CITY OF ALBUQUERQUE

August 15, 2022

**RE: Mojave Ridge Subdivision
6341 Mojave Rd. NW
Grading and Drainage Plan
Engineer's Stamp Date: 06/27/2022
Hydrology File: E10D024**

Based upon the information provided in your submittal received 06/27/2022, the Grading & Drainage Plan **is not** approved for Grading Permit. The following comments need to be addressed for approval of the above referenced project:

MOJAVE SUBDIVISION
GRADING AND DRAINAGE
DRAINAGE PLAN

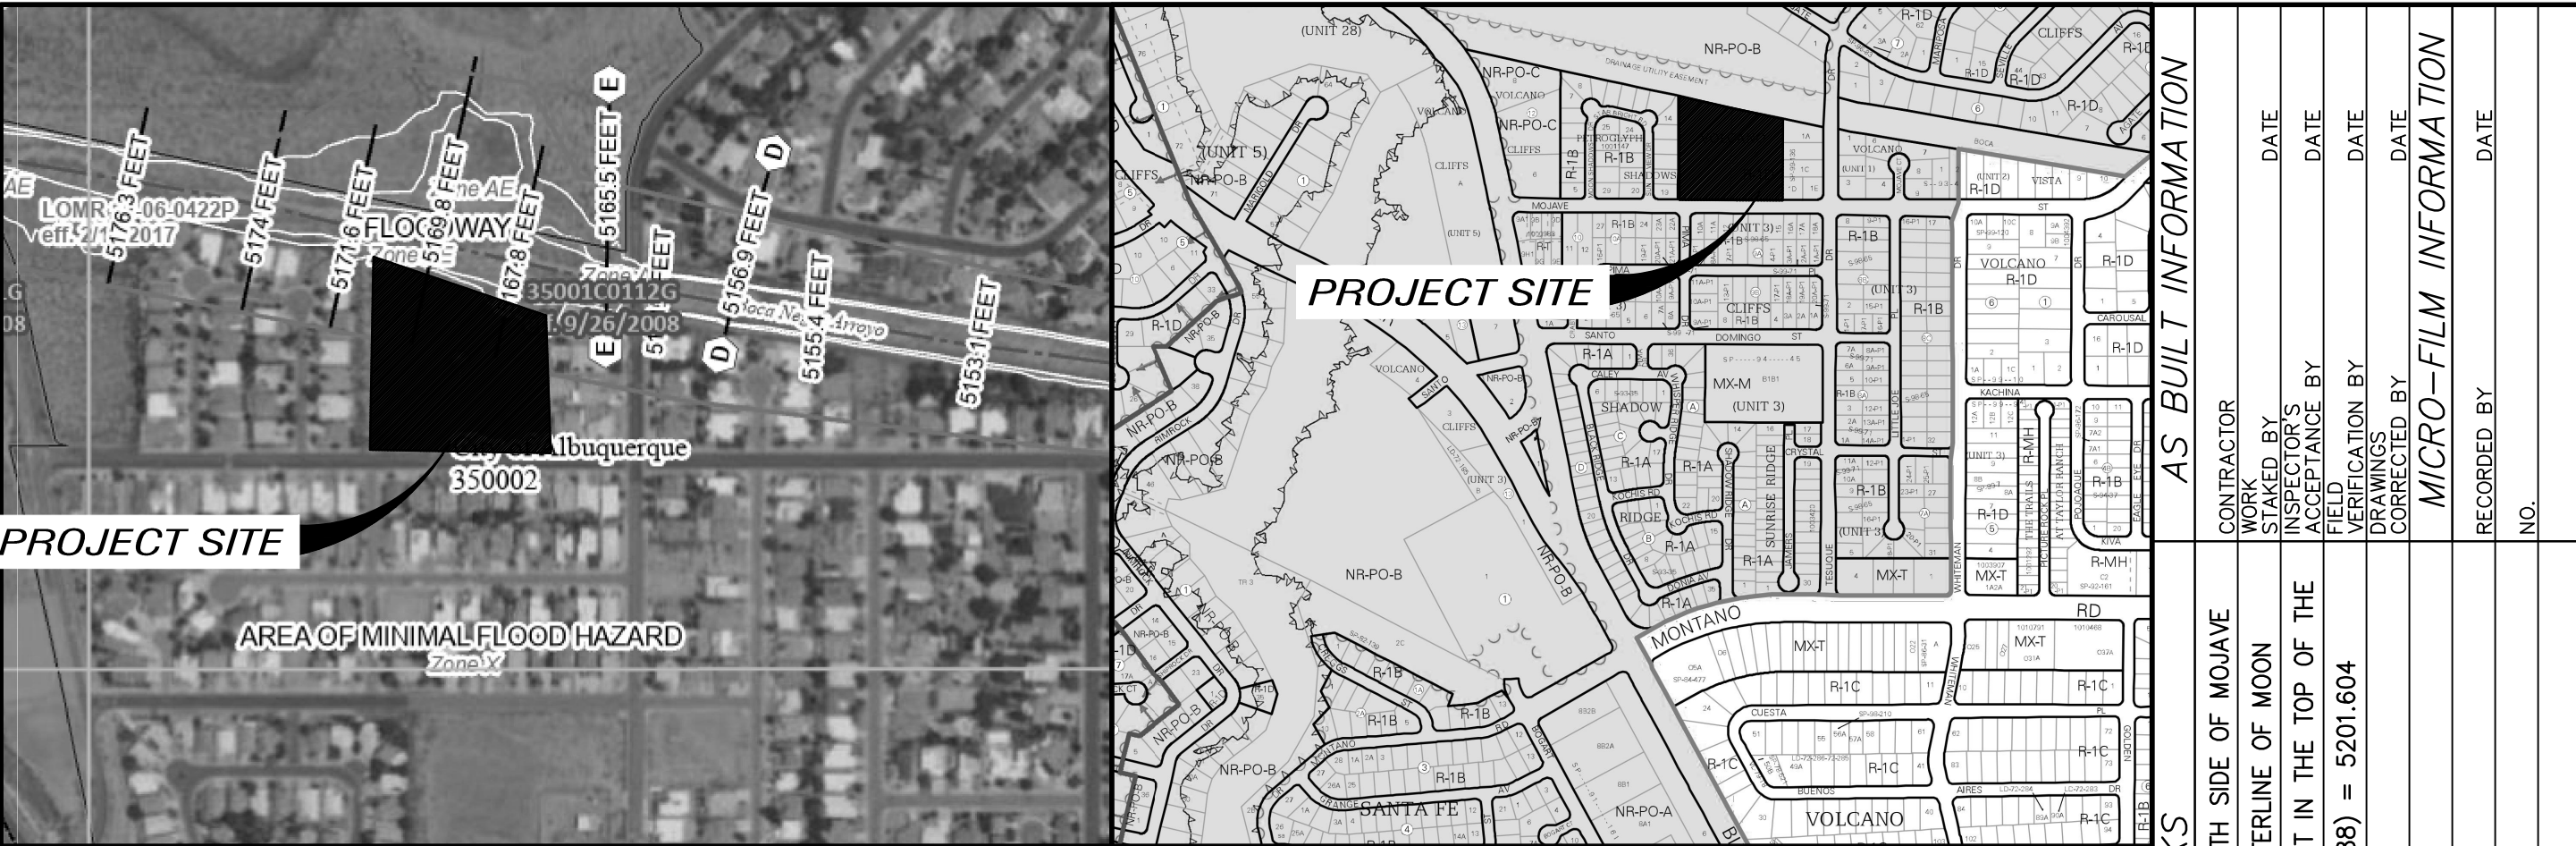
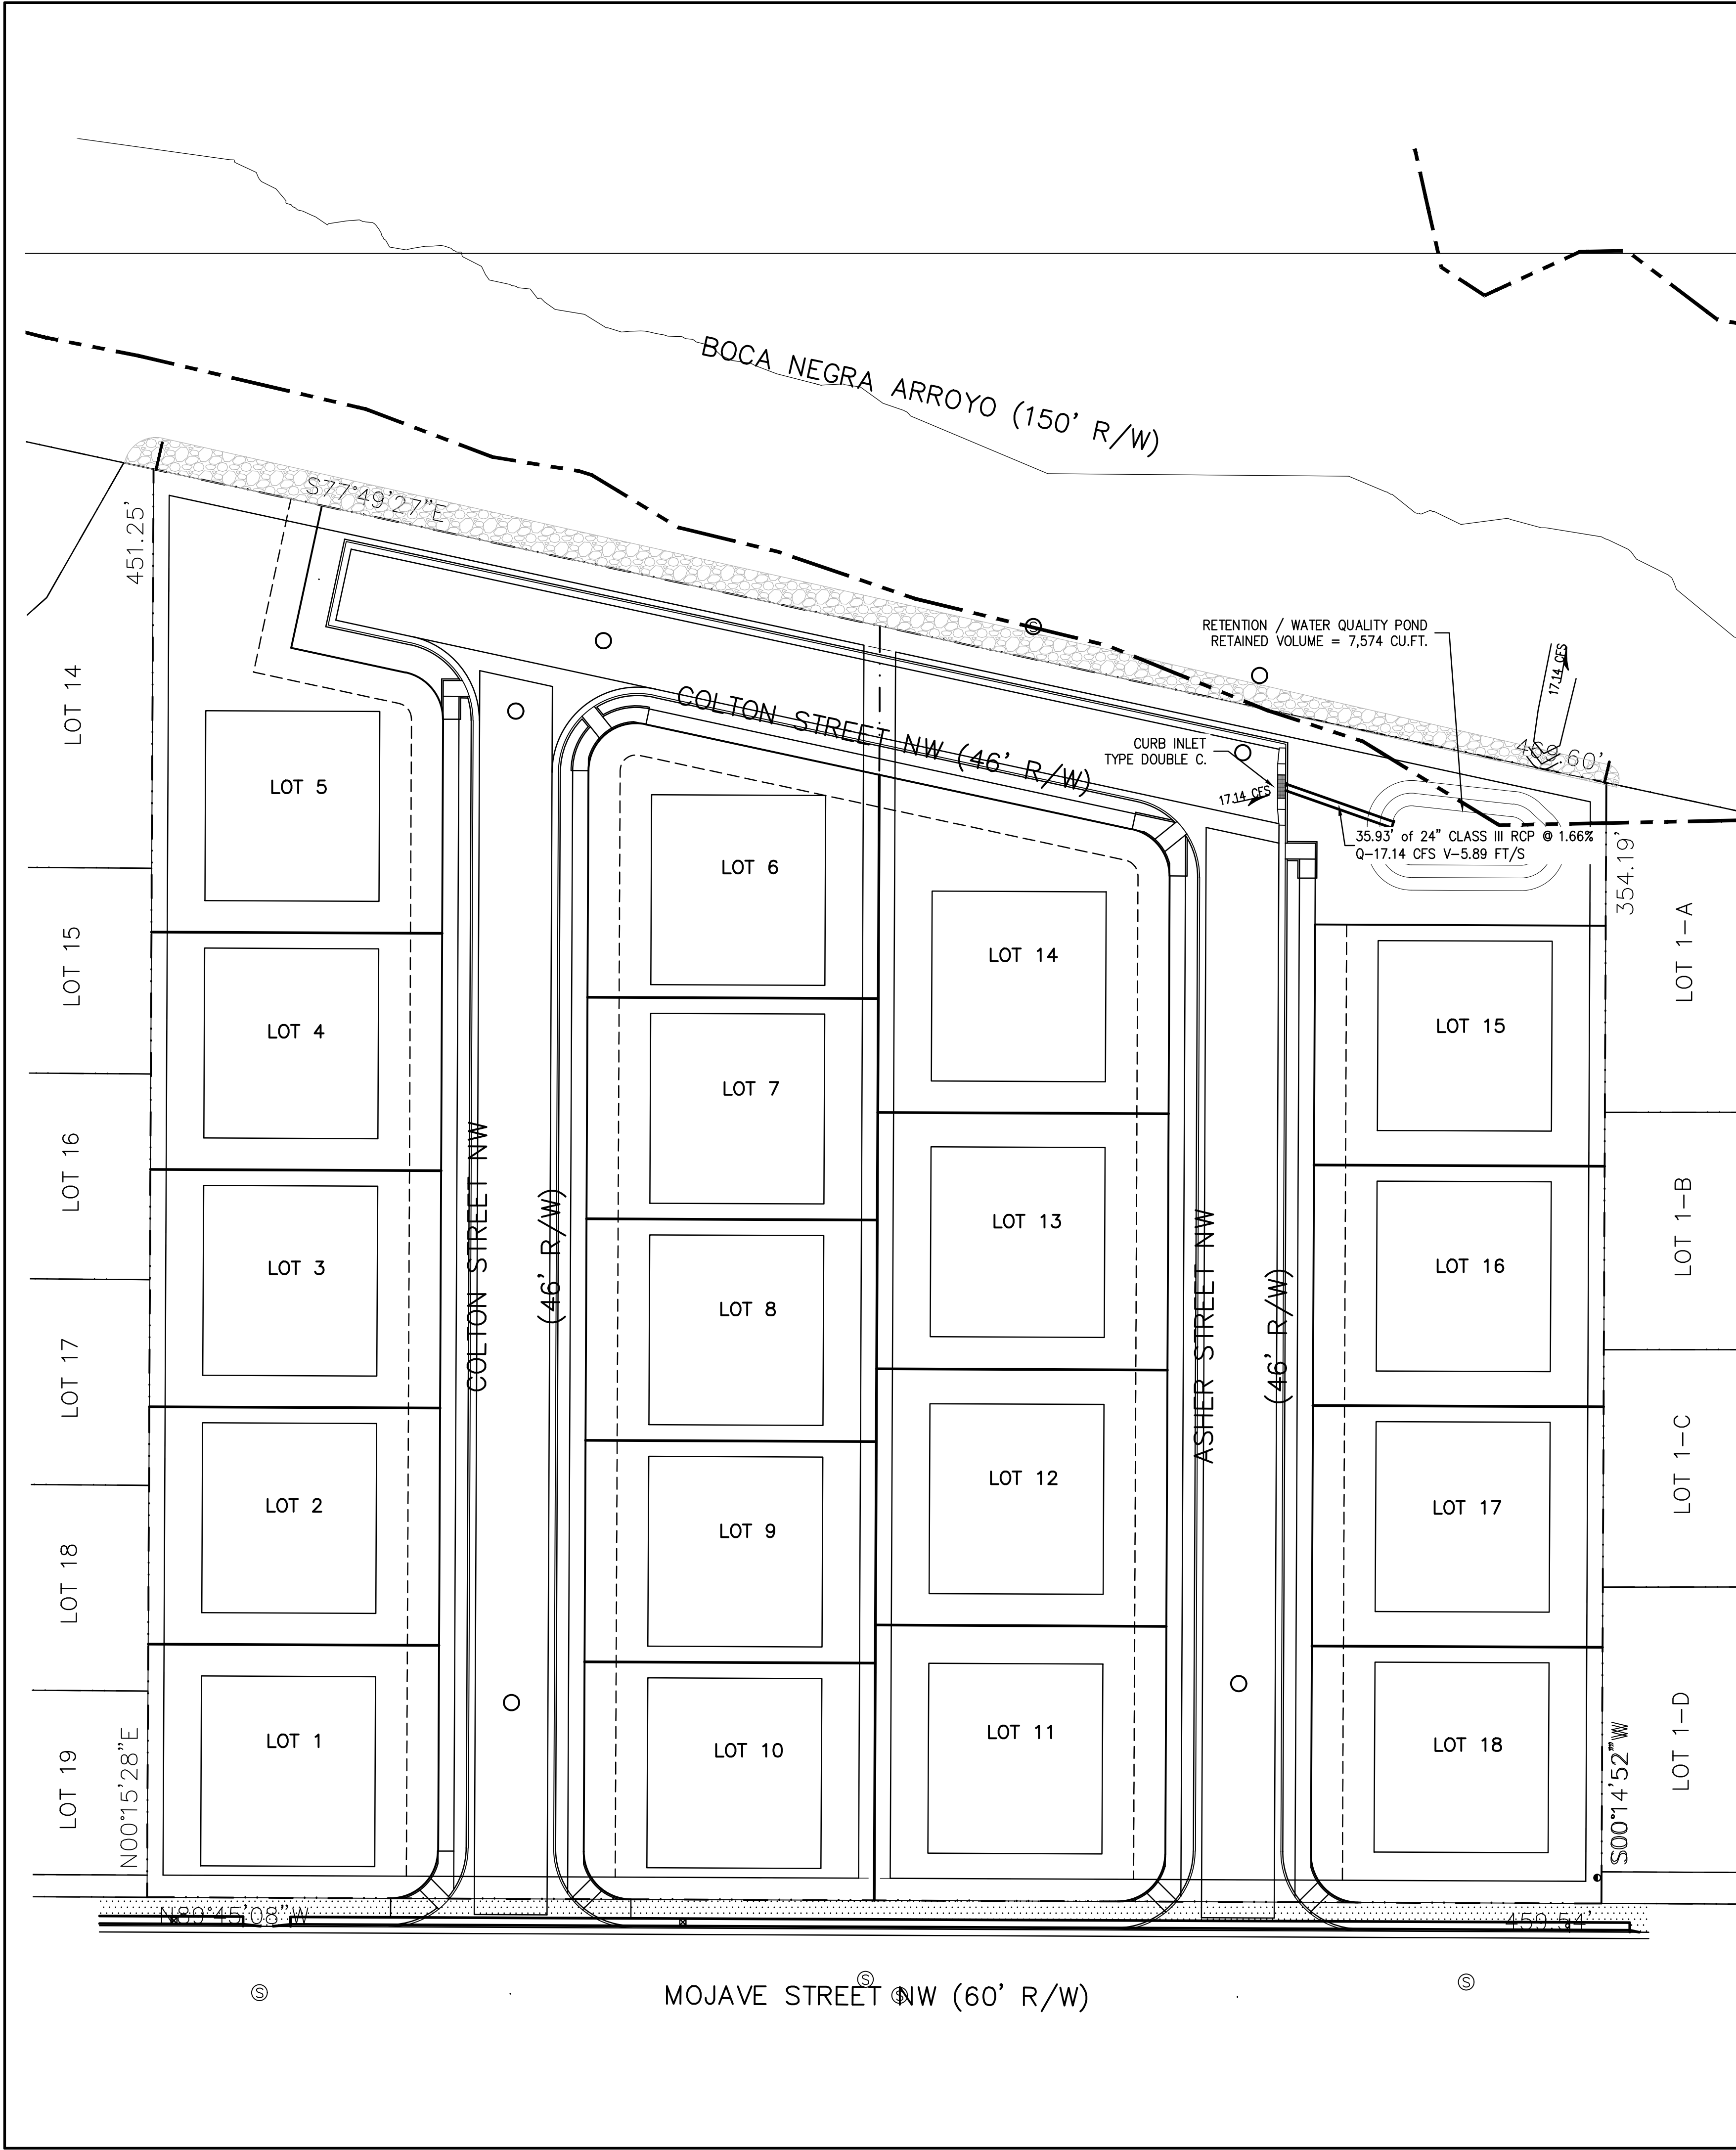
i. Street hydraulic capacity.

ii. HGL and if needed inlets based on report findings.

1. Calcs for inlets and flow going through them. If they are not needed, the report and EGL/HGL will dictate based on design with slope changes etc... I want to confirm that we are not sending water overtopping any C&G and potentially causing issues.

iii. LOMR study details and sections (4 sections) that are relating to this project.

1. Include calcs based on LOMR in the report. I do not have access to a copy so if you get one, please send it my way for our records. I am going to continue to search for one but as of right now, I have yet to find a copy.

iv. Please include all needed calcs in the report.
